**Development Review Board (DRB)
Review Comments
Utility Development Section
Reviewer: Kristopher Cadena, P.E.
Phone: 505.289.3301**

DRB Project No: PR-2019-002046	Date: 02/26/20	Item No: #2
Zone Atlas Page: G-15	Legal Description: Lot(s) TRACT 107B1A1 excluding portions of Right of Way and excluding a northerly portion, TRACT 107B1A2 excluding portion of Right of Way, TRACT in the SW Corner – TRACT 107B1B, TRACT 108A3A1A, TRACT 108A3A1B, and TRACT 108A3B, TRACTS 108A1A1B1B & 108A1A2B2, TRACT 108A1A2B1A, TRACT 107B2A2 excluding Rights of Way, TRACT 107B2A1, excluding portion of Right of Way, MRGCD Map#33 Location: 4600 EDITH BLVD NE (SE corner of COMANCHE RD NE AND EDITH BLVD NE)	
Request For: SI-2019-00032 - SITE PLAN

DECEMBER 10, 2019
SHEET No. SP-2

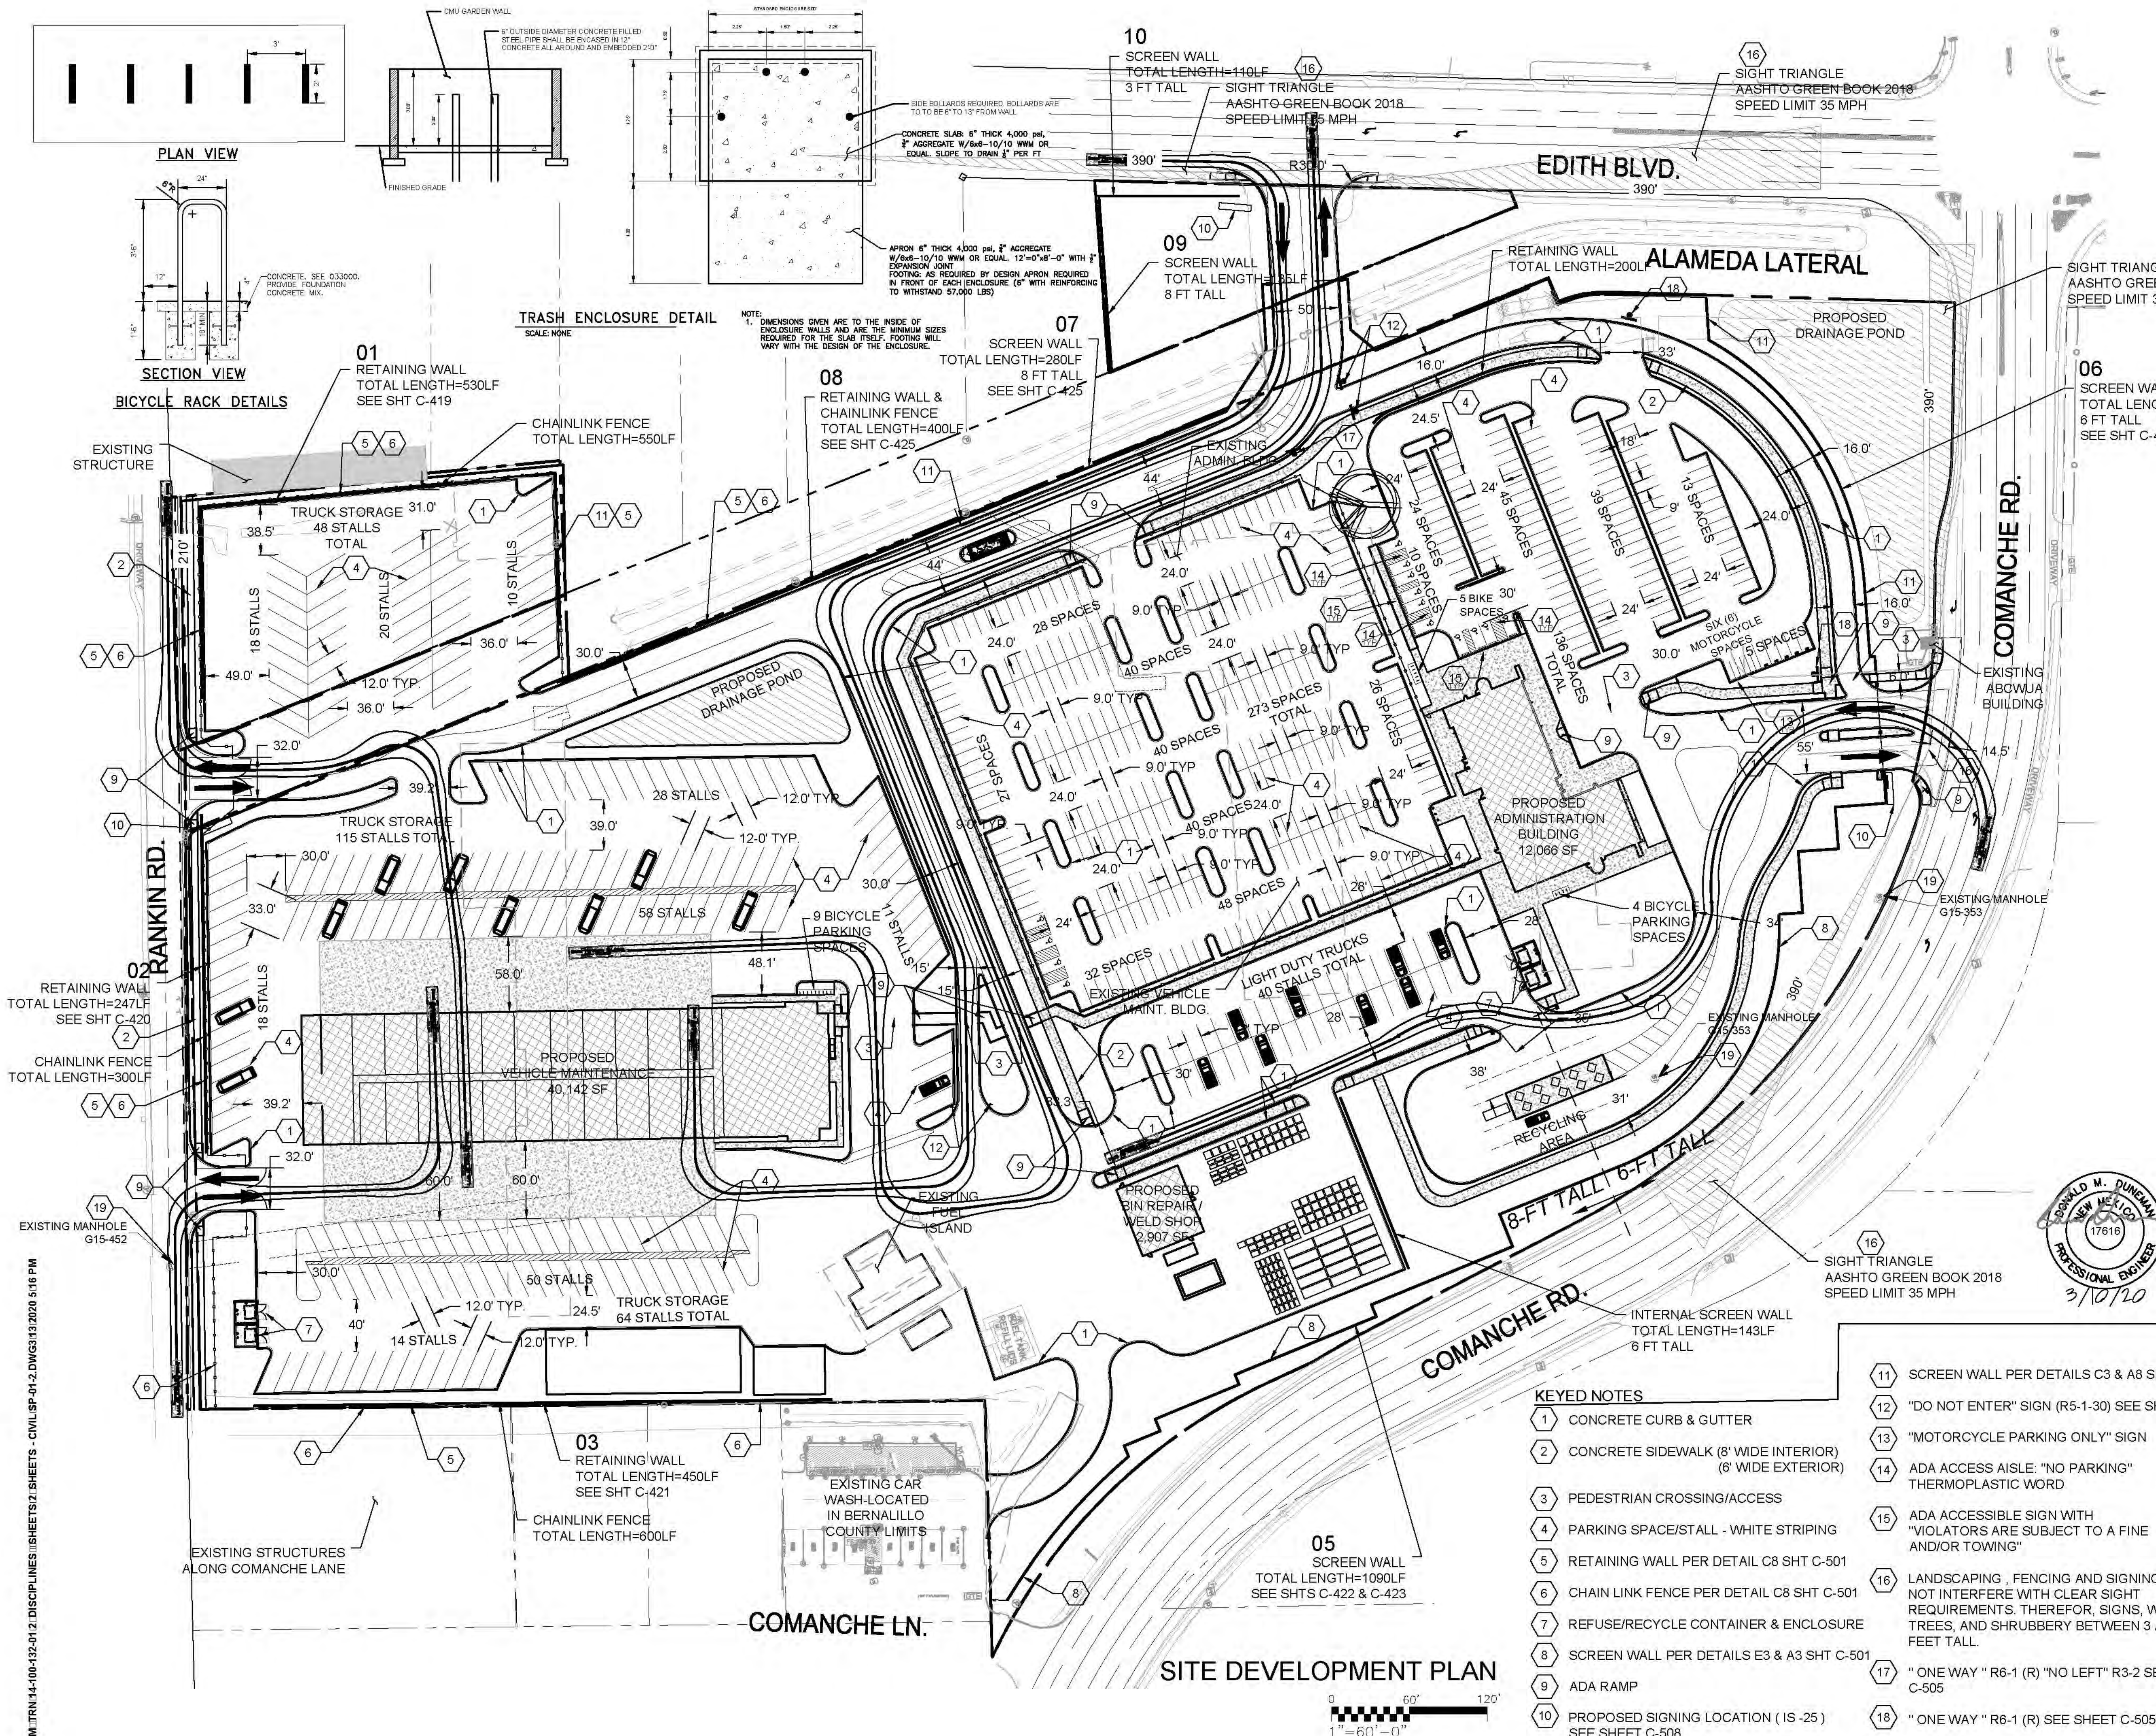
- a. There are proposed trees that appear to encroach within the sanitary sewer easement as well as some proposed where the existing “ABCWUA Building” is located.
- b. Utility plan
 - i. Per email from Collections (dated 12/6/19), it was requested that the utility plan label existing manhole G15-452, as well as the remaining onsite manholes along the Edith Interceptor. Labels shall be on the Site Plan and Utility Plan.
 1. A note shall be included that indicates access to the manholes shall be provided for maintenance and operations.
 2. A note shall be included that indicates possible manhole adjustments.
 3. Proposed fire hydrants (keyed note 12) shall be labeled as private.
